Shivesh Singh - Scottish Hospital Development, 2 Cooper Street, Paddington MP10_0160

**Re: Scottish Hospital, 2 Cooper Street, Paddington
MP 10_0160 & (aka) MP 10_0016**

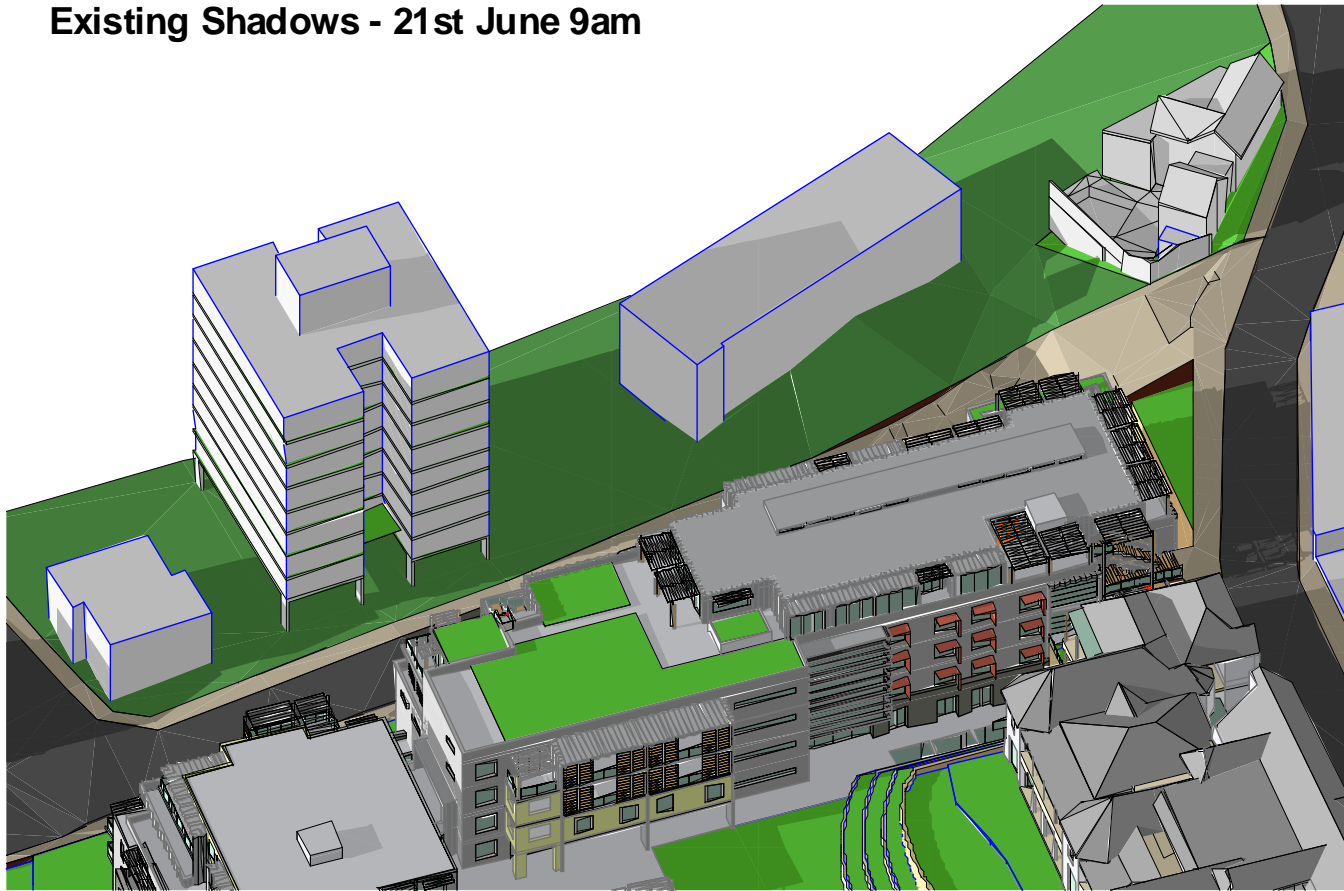
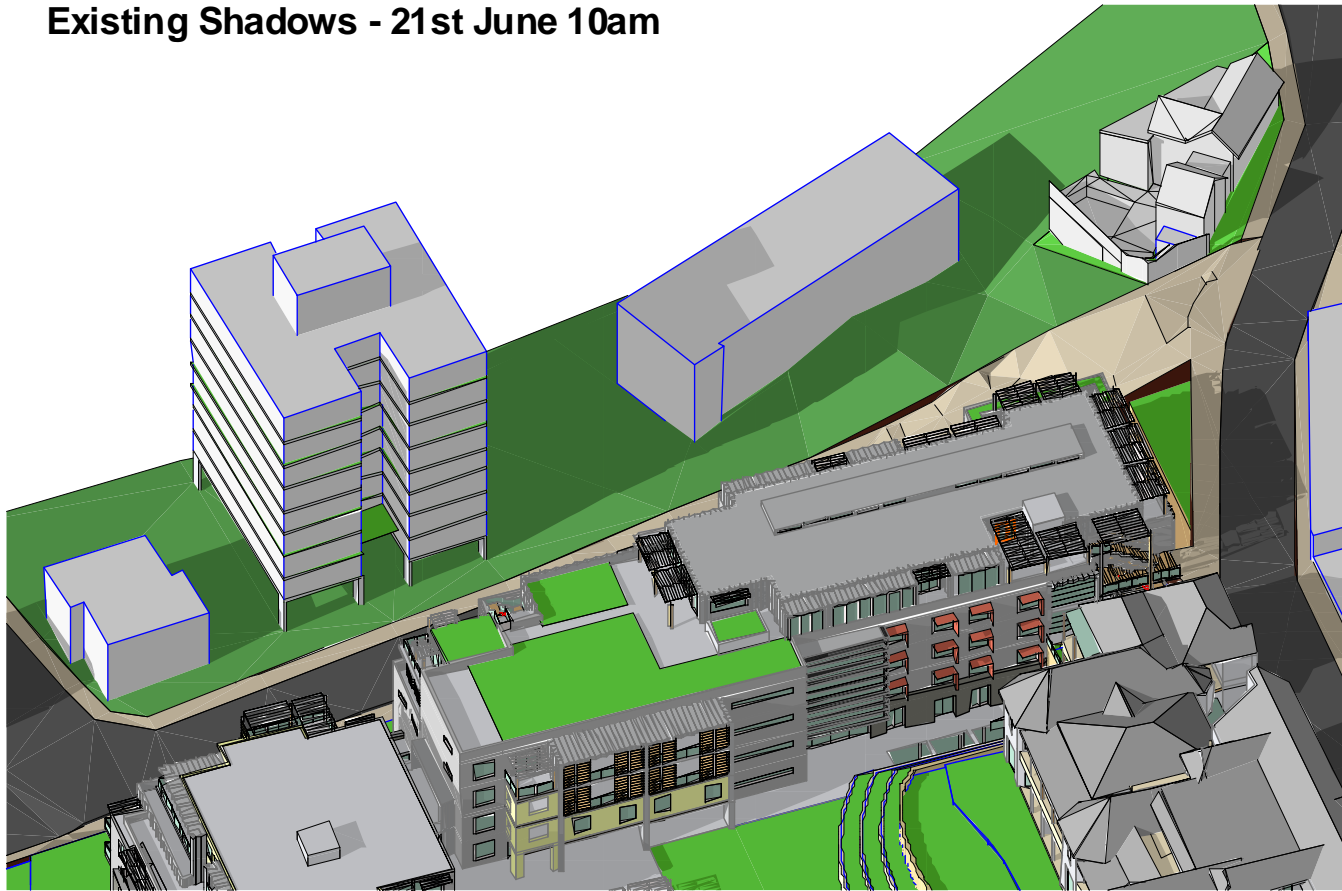
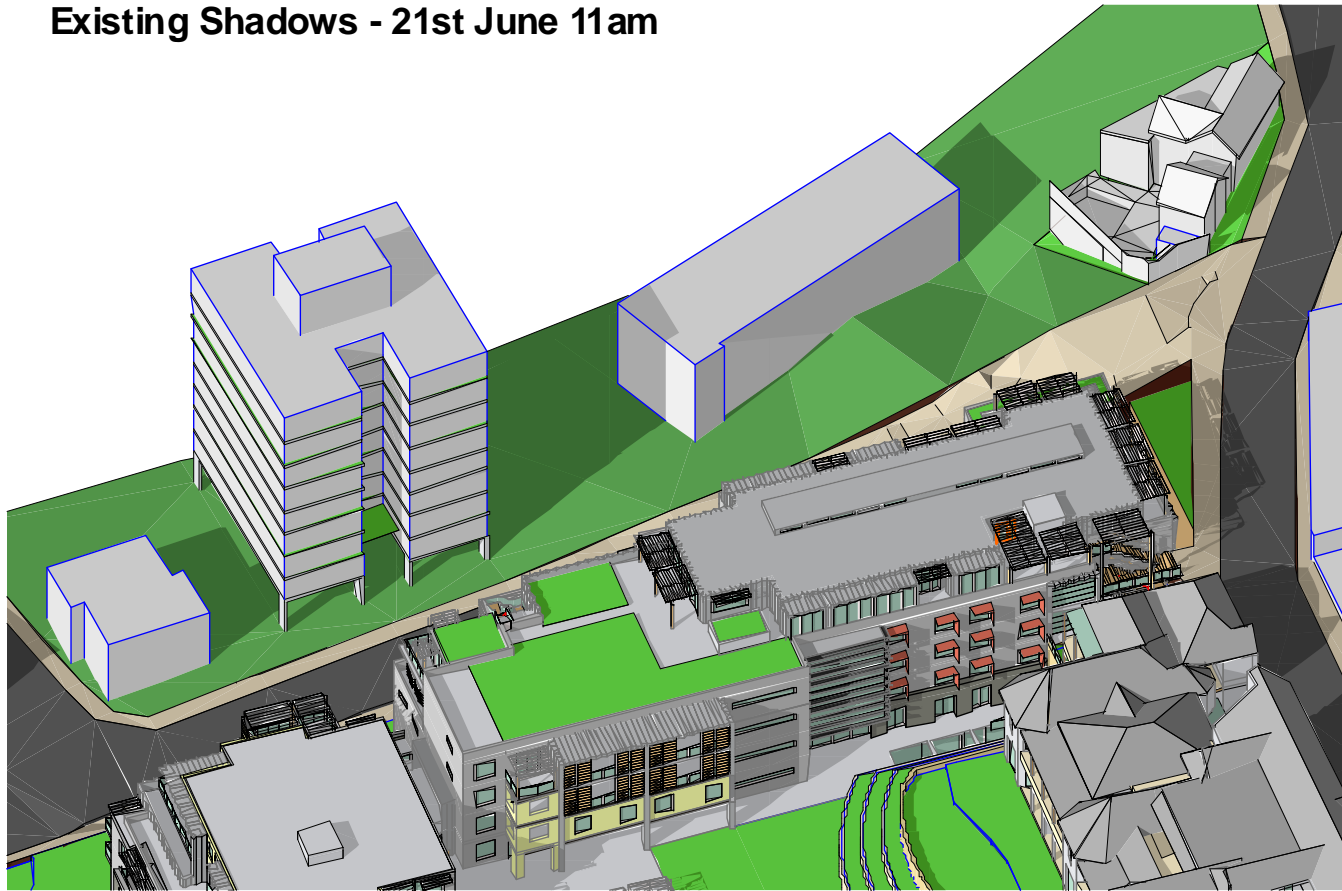
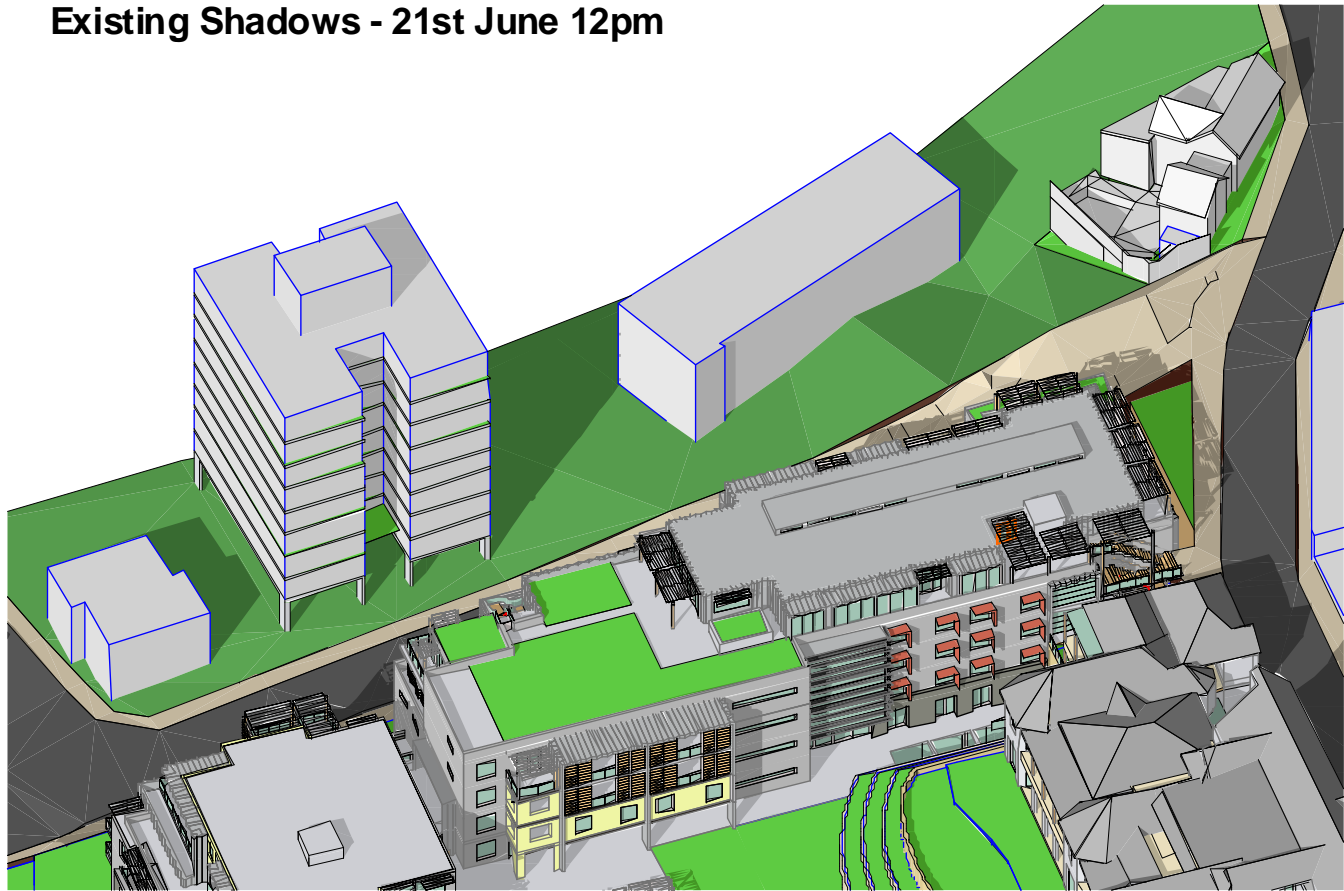
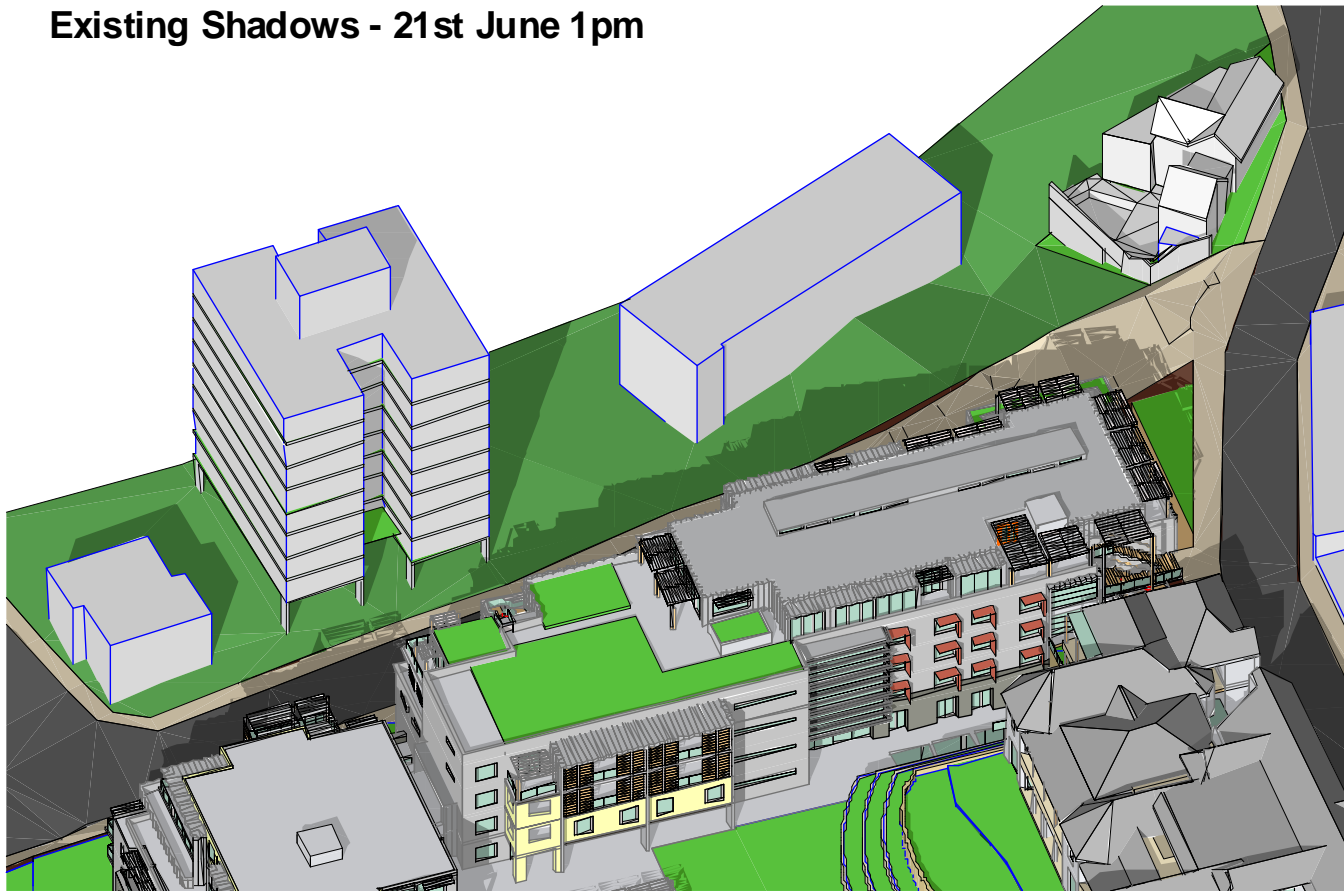
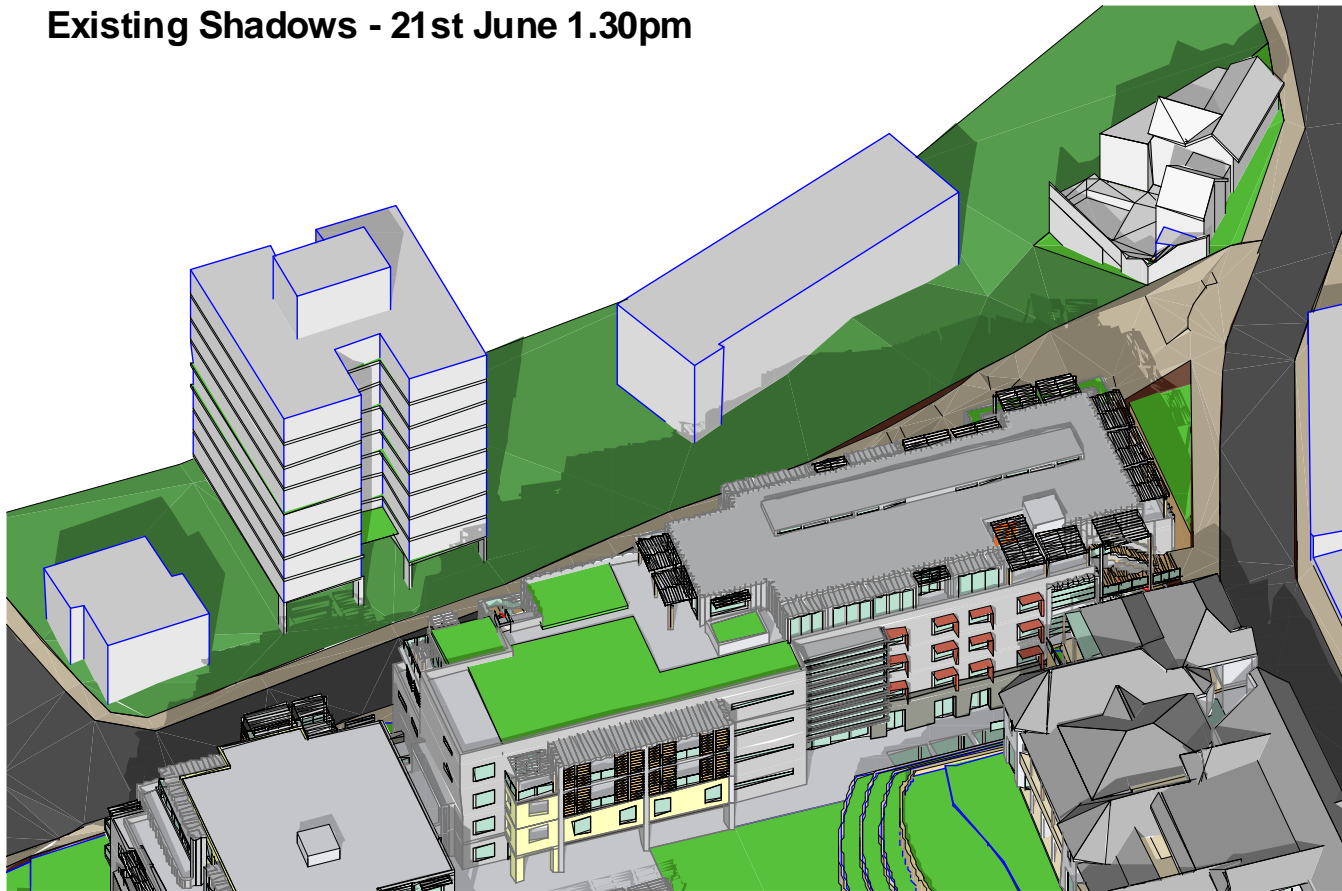
Coupled with its proximity to Brown Street and its excessive height and unsympathetic bulk, what scant filtered sunlight that is presently available will be totally obliterated by this 9 storey construction
